CITY OF ALBUQUERQUE

**Re: Del Webb @ Mirehaven Phase 2A
Request Pad Certification for lots 23-27, 29-33 – Not Accepted
Engineer's Stamp dated: 3-11-16 (H09D017F)
Certification dated: 6-14-17**

SHEET 7 OF 7

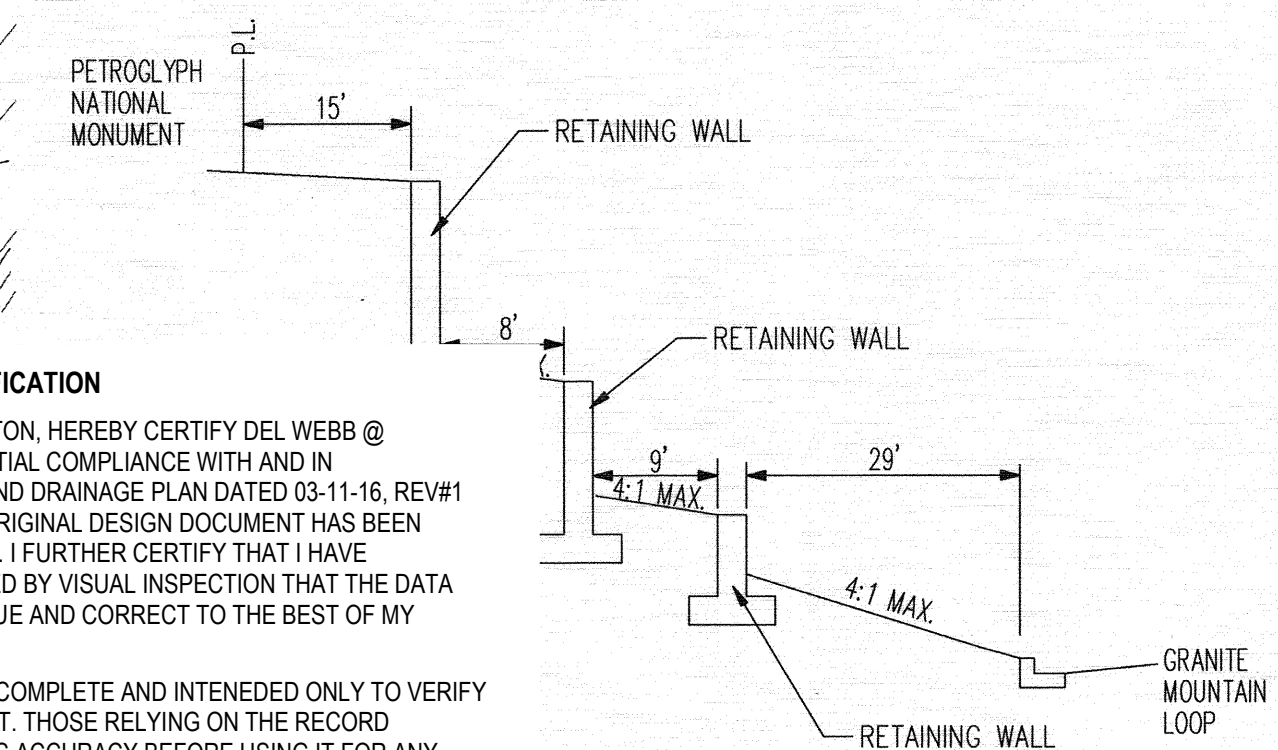
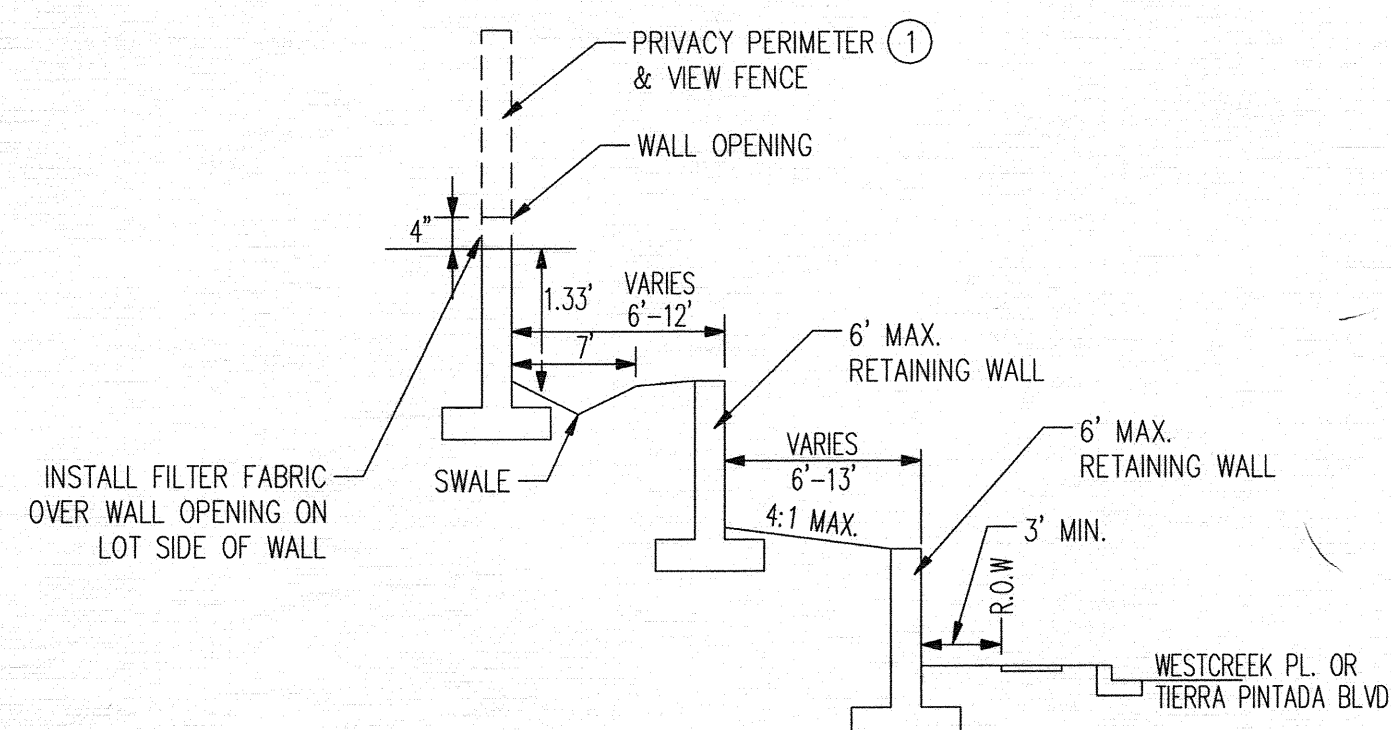
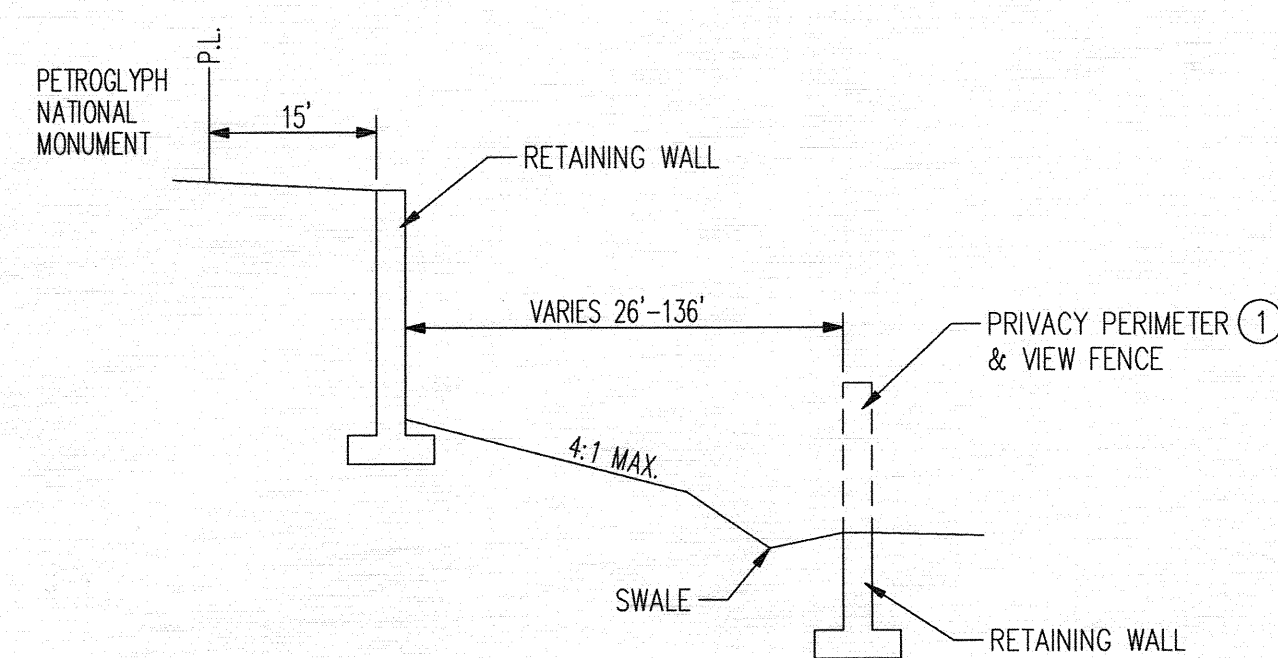
- The swale at rear lot lines of 16-27 needs to be completed and drain to the pond at the SE corner of the subdivision.
